FAO: Planning Department,
Tendring District Council

Ref: 21/02118/FUL
Date: 07/01/2022

HISTORIC BUILDINGS AND CONSERVATION ADVICE

RE: Land adjacent to 145 Connaught Avenue Frinton On Sea Essex

• FRONT (SOUTH) ELEVATION 1:100 •

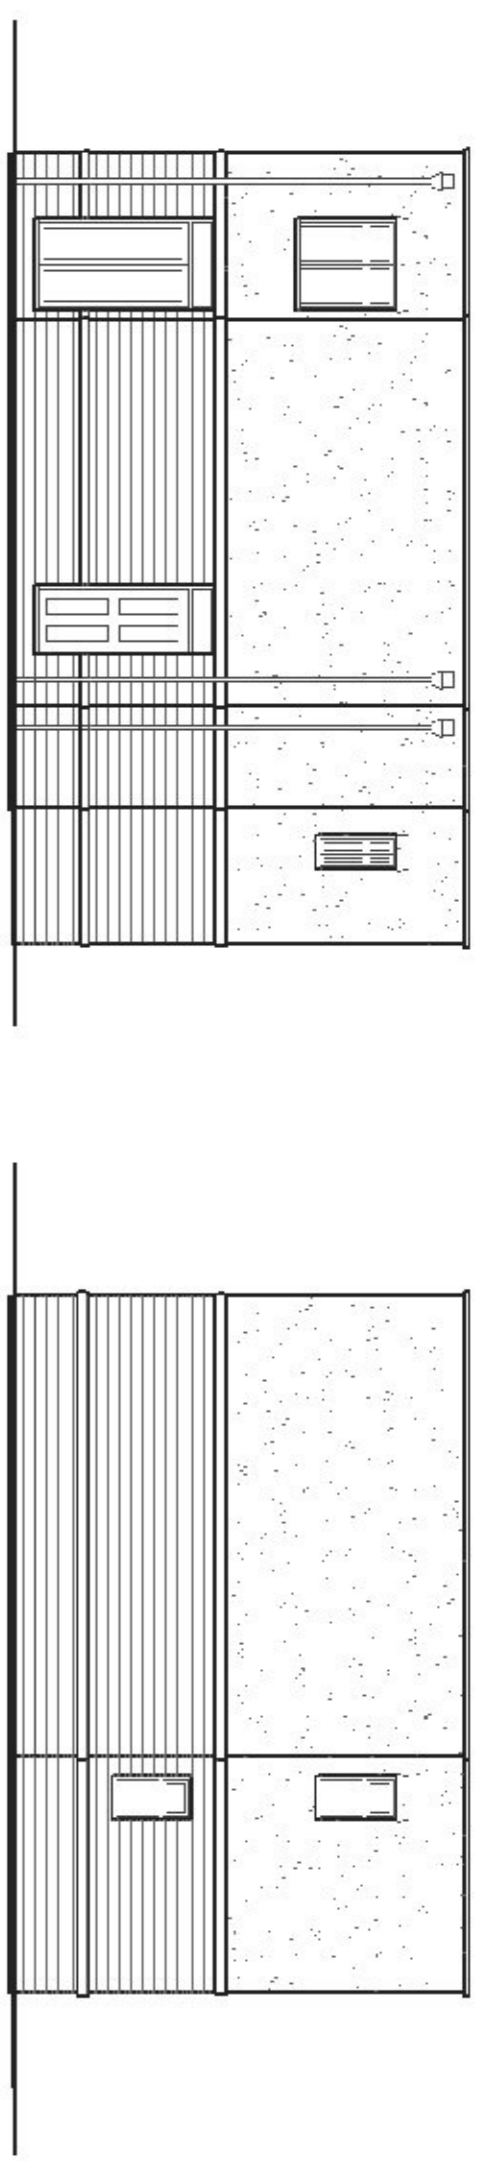
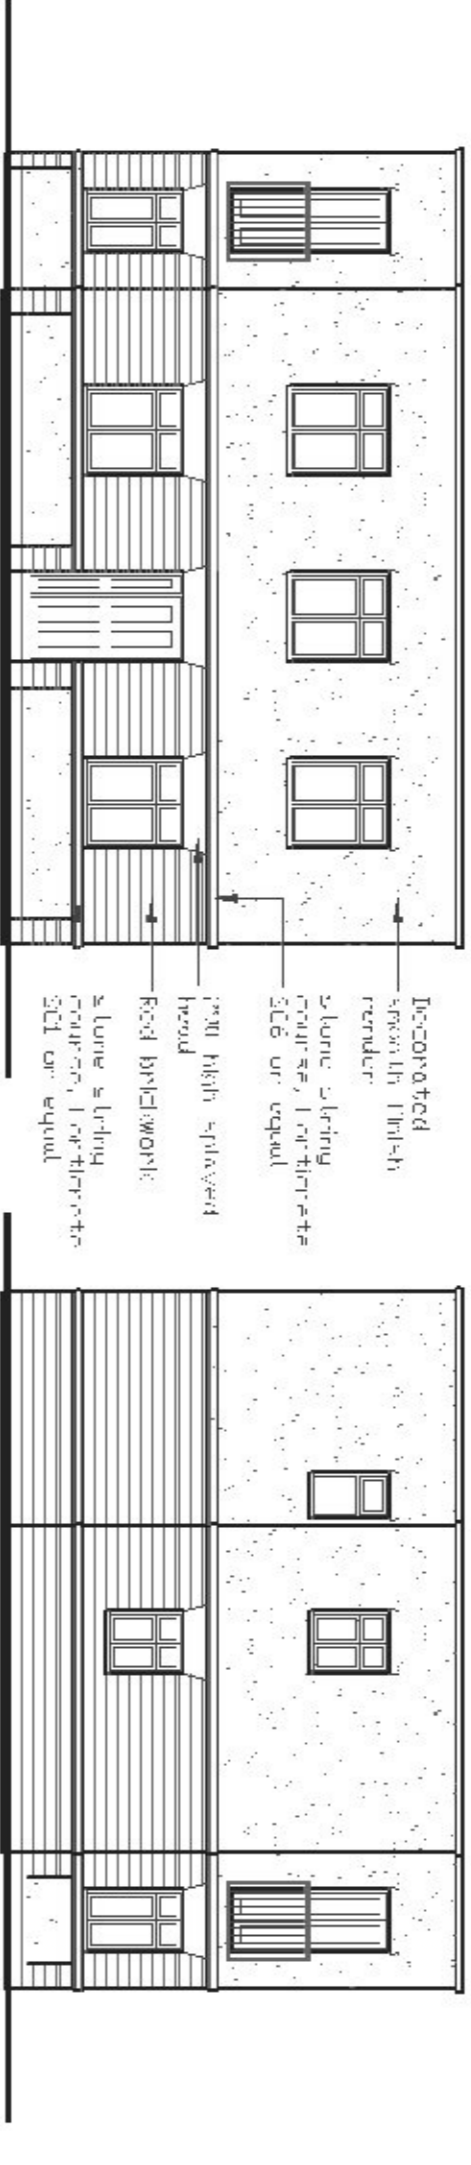
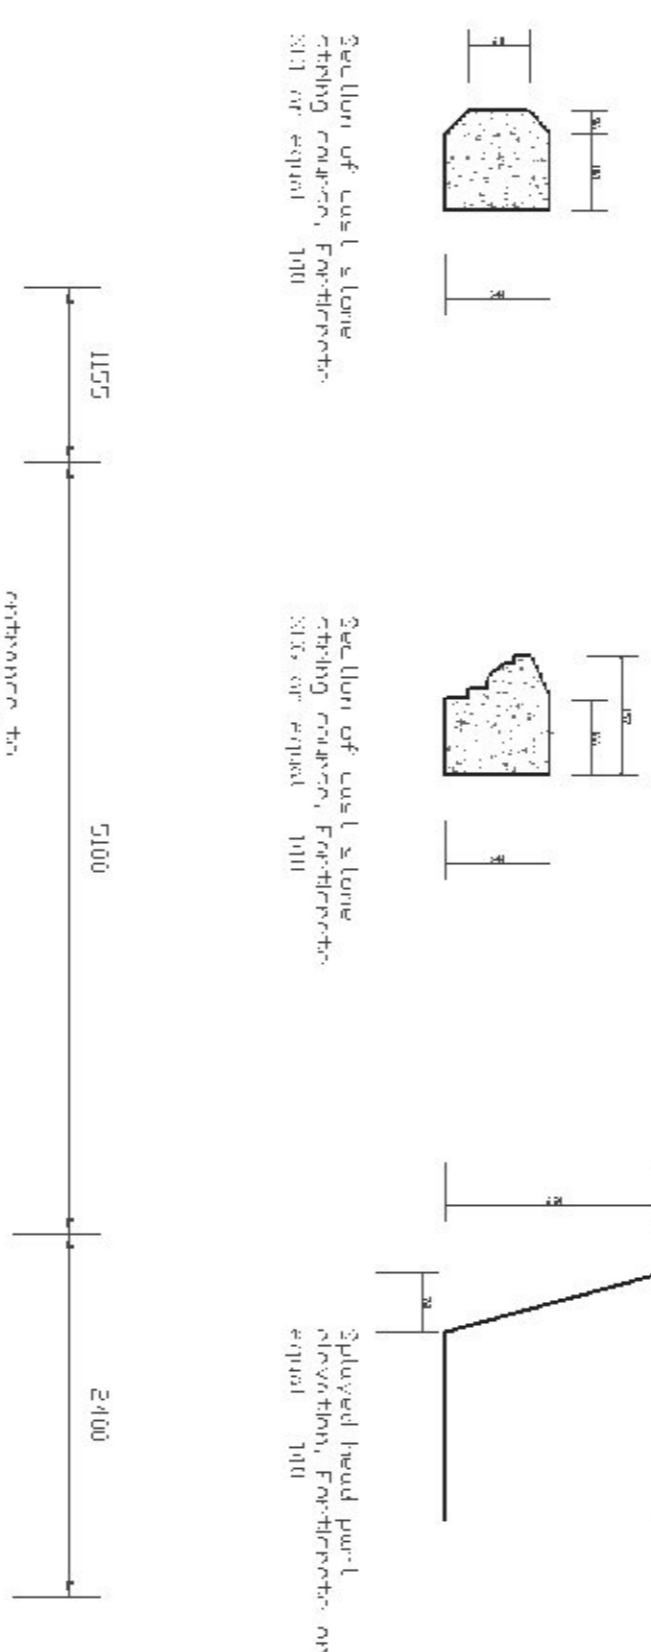
- Quality of the proposed design: Should the proposed site be deemed suitable for new development, the proposal, in the current form, will not make a positive contribution to the local character and distinctiveness of the area. The proposed design, as stated in the attached Design Statement, uses Ashlyns House as architectural reference for the new development. Ashlyn House was originally built as a commercial unit. The ground floor still retains most of its fine original features, but the building was unsympathetically extended at some point in the past with the construction of a first floor extension of poor design and the introduction of details that

are not distinctive of the local architecture (e.g., the flat roof, the Juliet balcony, the casement windows). This caused an irreversible harm to both the significance of the non-designated asset and the character and appearance of the Conservation Area. The elevations of the proposed development replicate those elements that are considered to have a negative impact on the heritage assets and therefore cannot be recommended for approval. This new building references the poorest elements of the streetscape and would average down the architectural quality of the Conservation Area;

- Context: the proposed plans and elevations do not provide any information on the context of the proposed development and its relationship with the surrounding buildings within the Conservation Area. Based on the information provided, it is not possible to assess how the new development would change the local streetscape and how it would contribute to the distinctiveness of the area;
- Materials and details: the applicant have not provided adequate information on the materials to be used or construction details at adequate scale of representation. The scale and quality the proposed drawings (particularly of the elevations) are not always adequate to assess the proposal and most of the annotation are not readable; and
- The proposals include features such as street-fronting Juliet balconies which will not be supported in principle.
